Your Ref: OWPC20088
Our Ref: M/114/18/PL 08-08-2018
Please ask for:
Mrs D Johnson

1 No. replacement dwelling.
5 Central Drive Middleton-On-Sea

Thank you for your internet representation made on 5th October 2018 which has been recorded as '**an objection**' with the comments as follows:

PROJECT TITLE Proposed development at 5 Central Drive	DRAWING TITLE Proposed Elevations		No	REVISION	DATE
	STATUS Planning Application				
	SCALE 1:100 @ A3	DATE 20.07.2018			
	DRAWN BY AP	DRAWING No PA-270-07

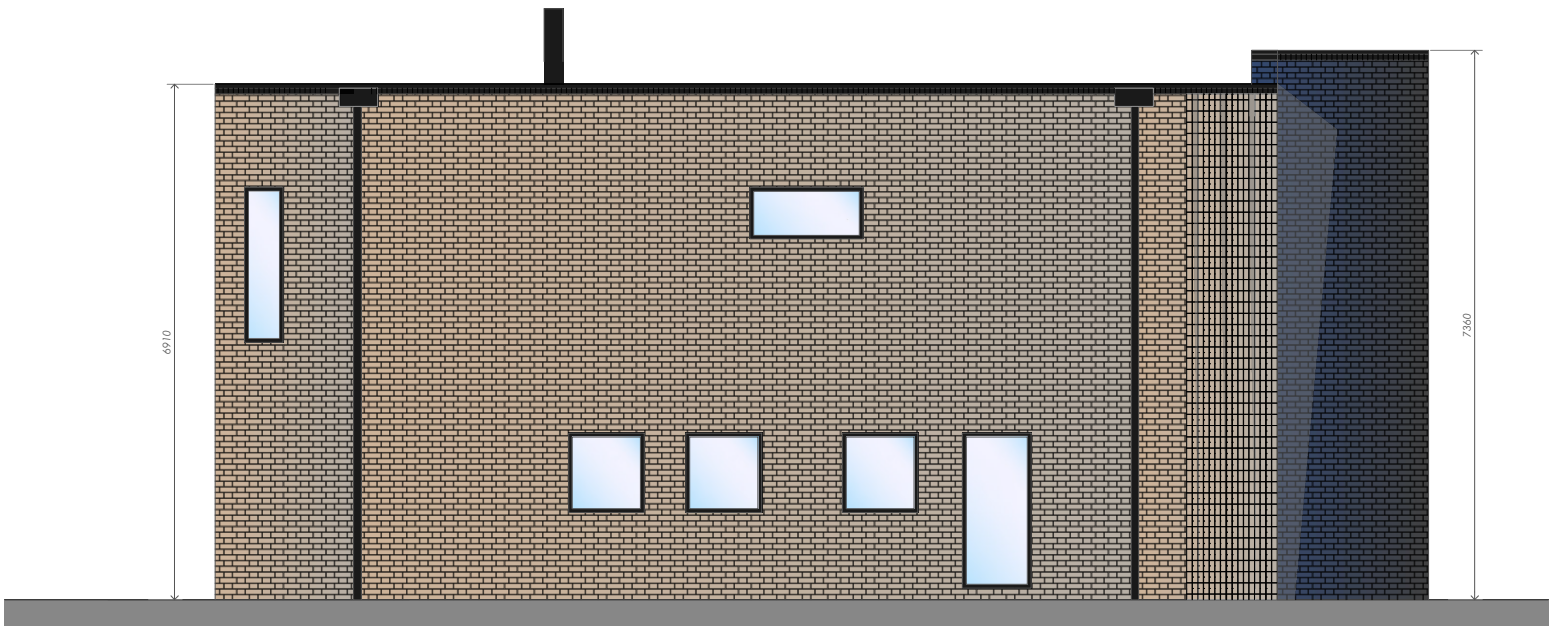
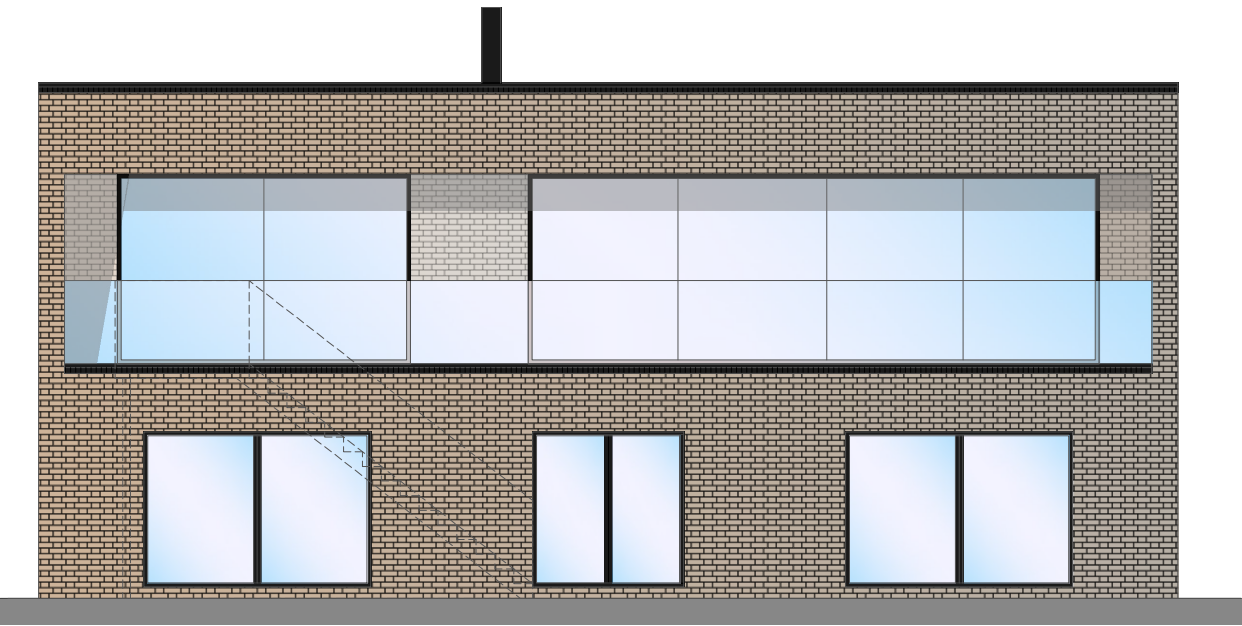
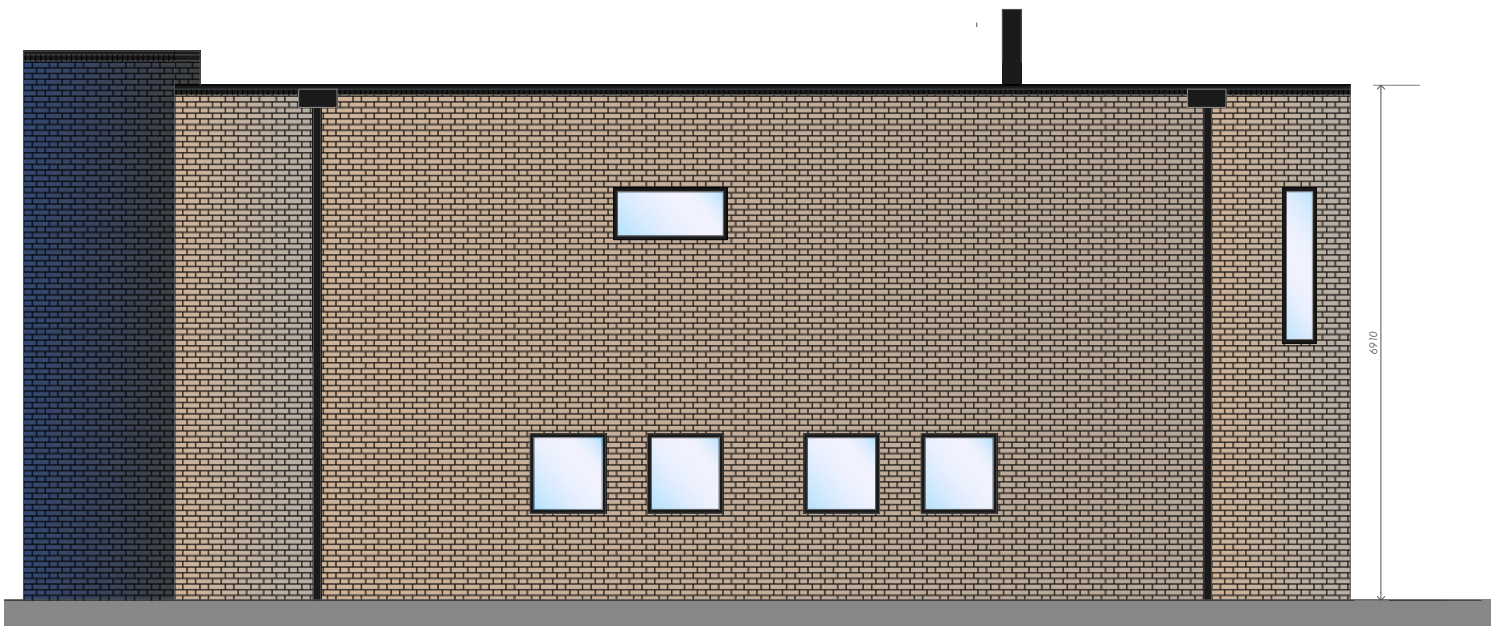
*My wife and I are concerned that the proposed design of the new property to be built .
The basis of our concerns are that the development does not fit in nor is it similar with other properties in the neighbourhood , The Elmer Sands Estate is a conventional coastal area of residential properties and which consist of typical seaside housing designs .
There are a lot of different designs many of which embrace the coastal design and which include many properties of the upside down concept .
The majority of properties appear to have been built between the 1920's and the 1940's and designed of that era and this reflects the tone and feeling of the area.
It is submitted that the applicant has failed to demonstrate that the replacement dwelling positively responds to its immediate surroundings to create a visually pleasing dwelling .
The use of brown bricks as proposed does not blend in with the neighbourhood but in fact it does the opposite ie it stands out and looks out of place .

The applicant States that flat roofs are a common site on many yesteryear coastal properties .
Our comment to that is that there are no more than less of a handful of flat roofed properties in the neighbourhood which reinforces what we have said about the design .
The applicant states that the proposal is a flag shaped design for the area and will no doubt encourage similar schemes to be adopted .
The suggestion of a flagship affirms that this a development that does not fit in nor is it similar with other properties in the neighbourhood.
Whilst the proposal is made on the basis of using the existing footprint , it is the case that the rectangular design proposed will significantly increase overall the size of the property and its impact on the neighbourhood .
The rectangular design reduces the space and hence the view that is currently afforded on both sides of the property and this will visually impact both from the neighbouring properties but also the many residents and visitors to the estate .

In summary we are concerned that the proposal is too extreme and has little in common with its neighbours which generally have a maritime influence with common usage of timber , cladding , decking , masts etc .
The design is contemporary and not in keeping with the neighbourhood.
The impact of the proposal on the seaview is to significantly reduce the view by reducing the space between the development and its immediate neighbouring properties .
In short it is not visually pleasing to its immediate surroundings and will stand out as an eyesore and not as the applicant says in a way that is sympathetic to the neighbourhood.
The neighbouring property at 3 Central Drive has recently been granted planning permission to extend the property including the first floor and which will also reduce the gap between it and number 5 Central Drive with a reduction of the seaview there .
However this proposal at number 3 is one which fits in with the neighbourhood .*
